Re: Planning Application 20/0418

**Address: The Caravan Angram Green Farmhouse West Lane Worston
BB7 1QB**

Description: Construction of detached replacement dwelling.

proposed site plan

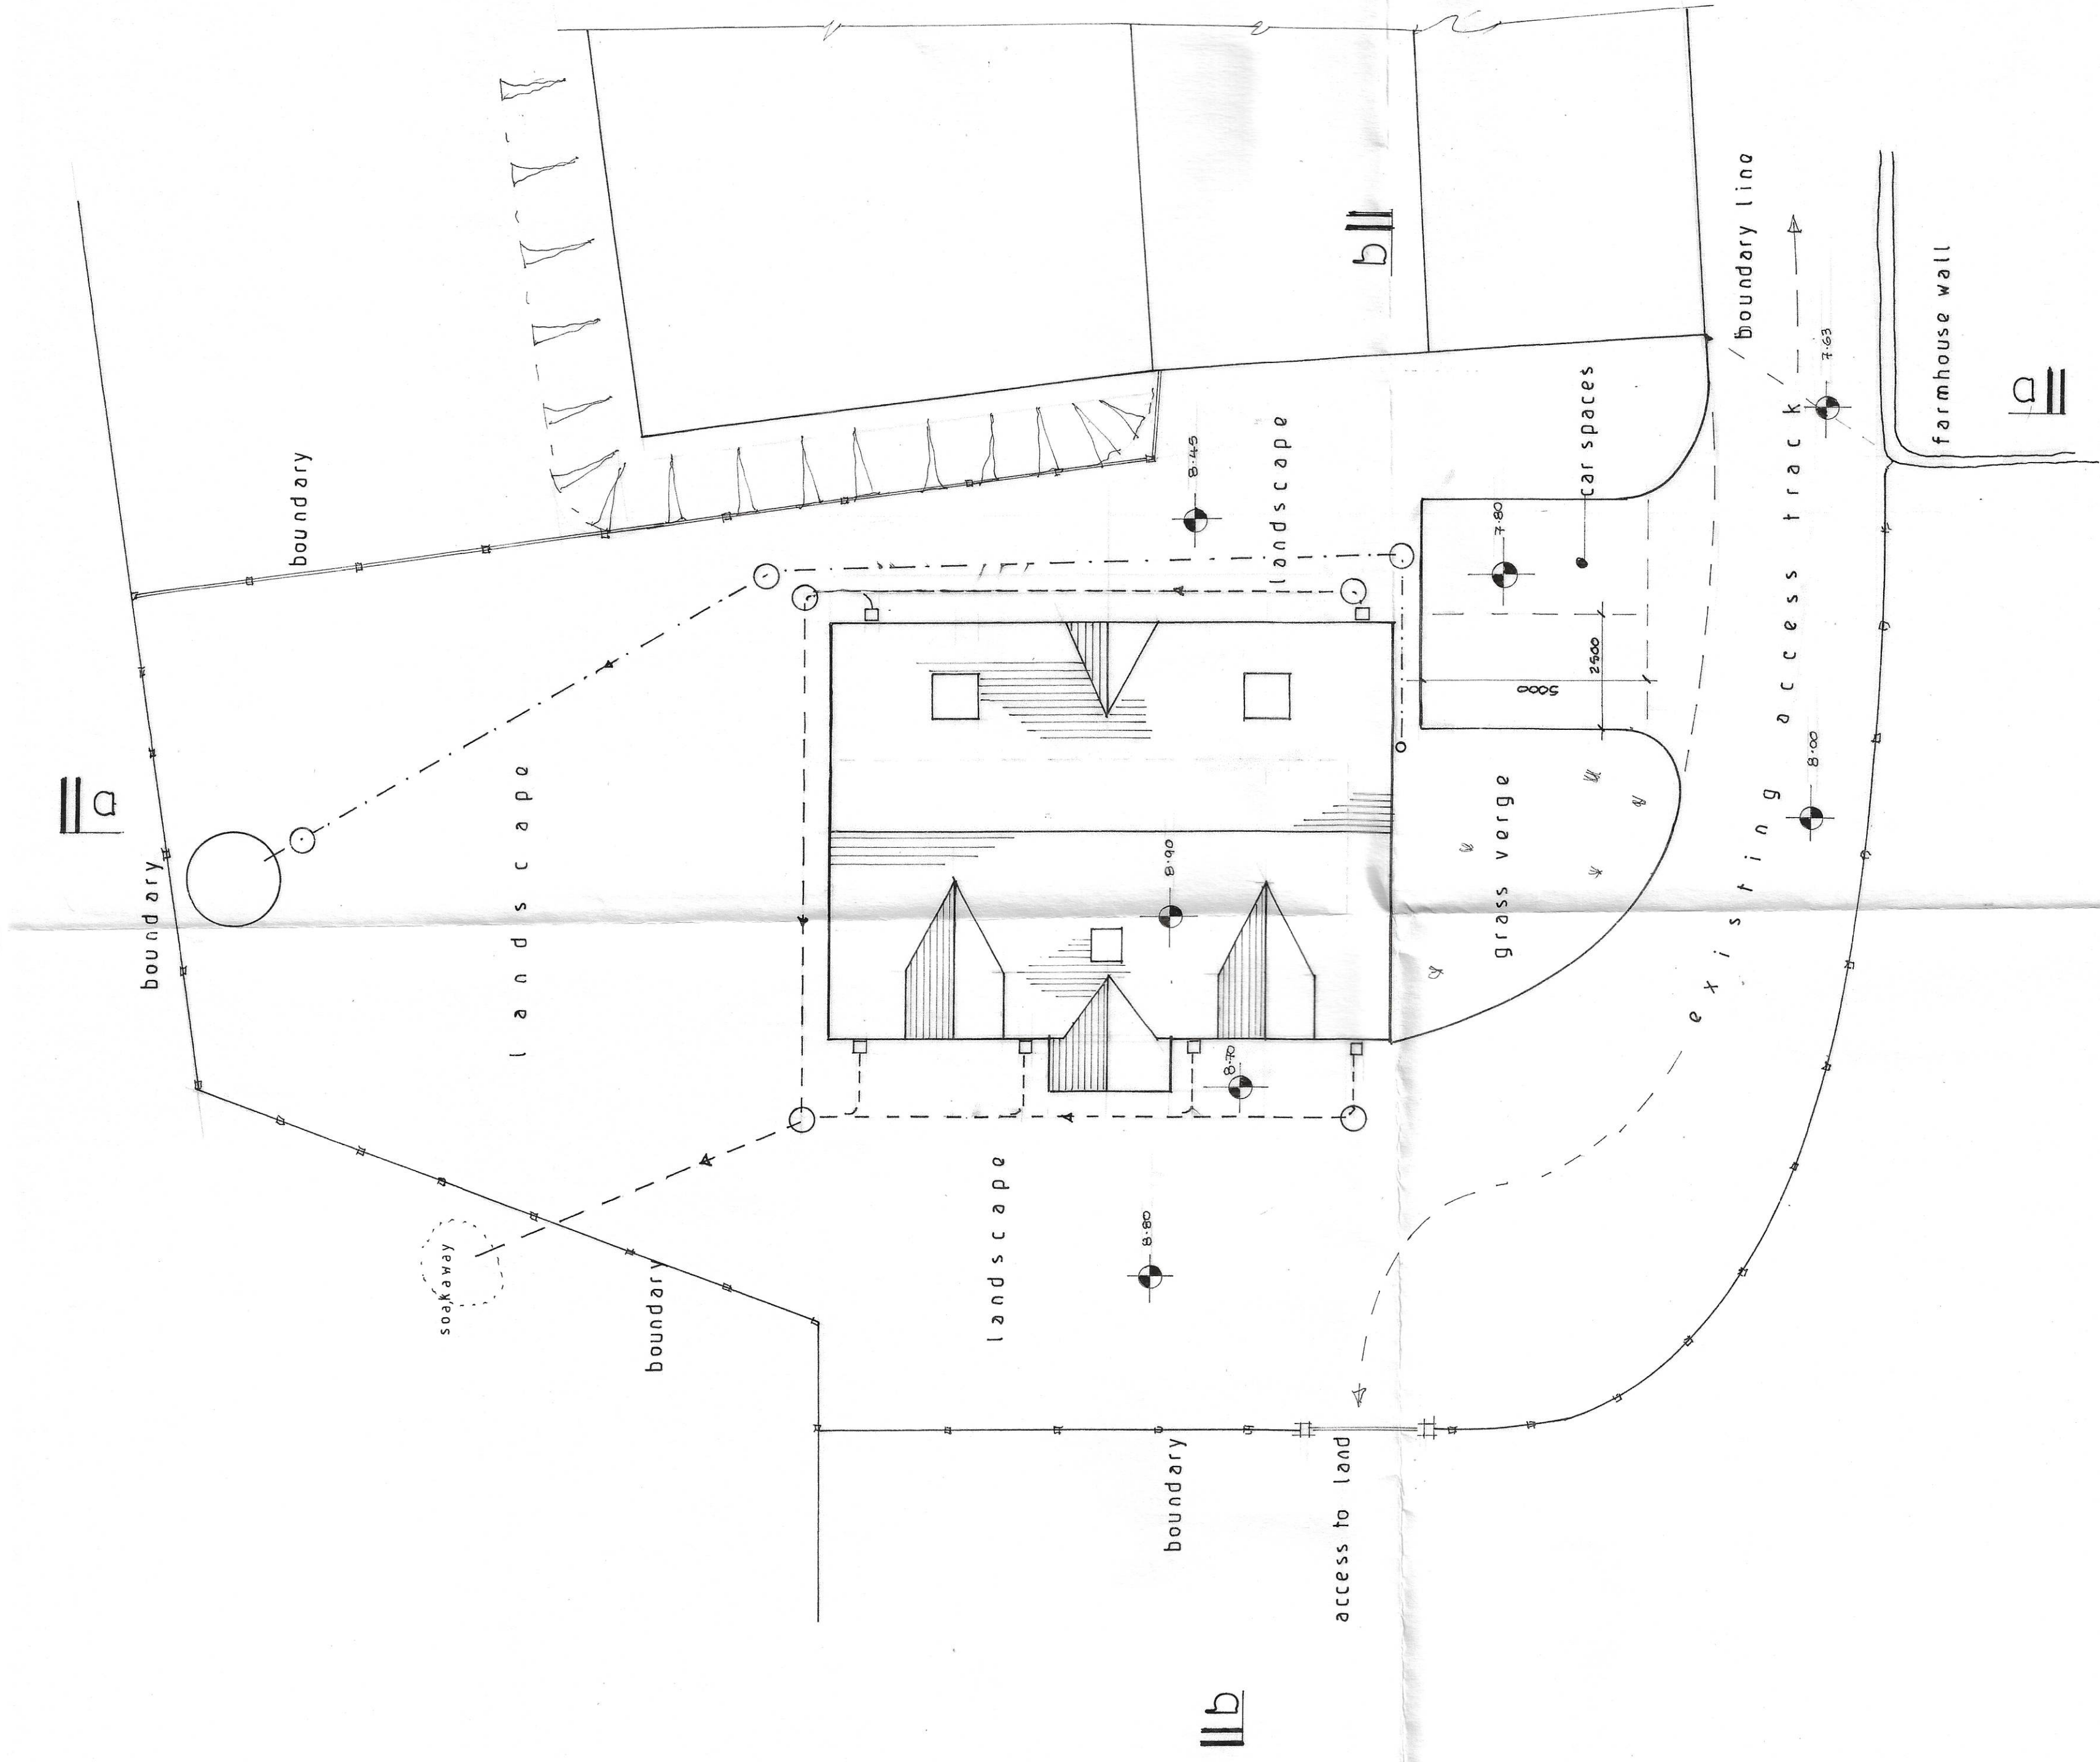
With respect to this application whilst we would not object to the principle of the application there is a concern regarding the possible access to the public highway. This access is not shown on any of the supporting documentation for the application.

In order to fully support this application we would request that the access is paved in a bound material from the rear edge of the carriageway to prevent debris being carried onto the public highway.

It is expected that this work will need to be carried out as part of a Section 278 agreement.
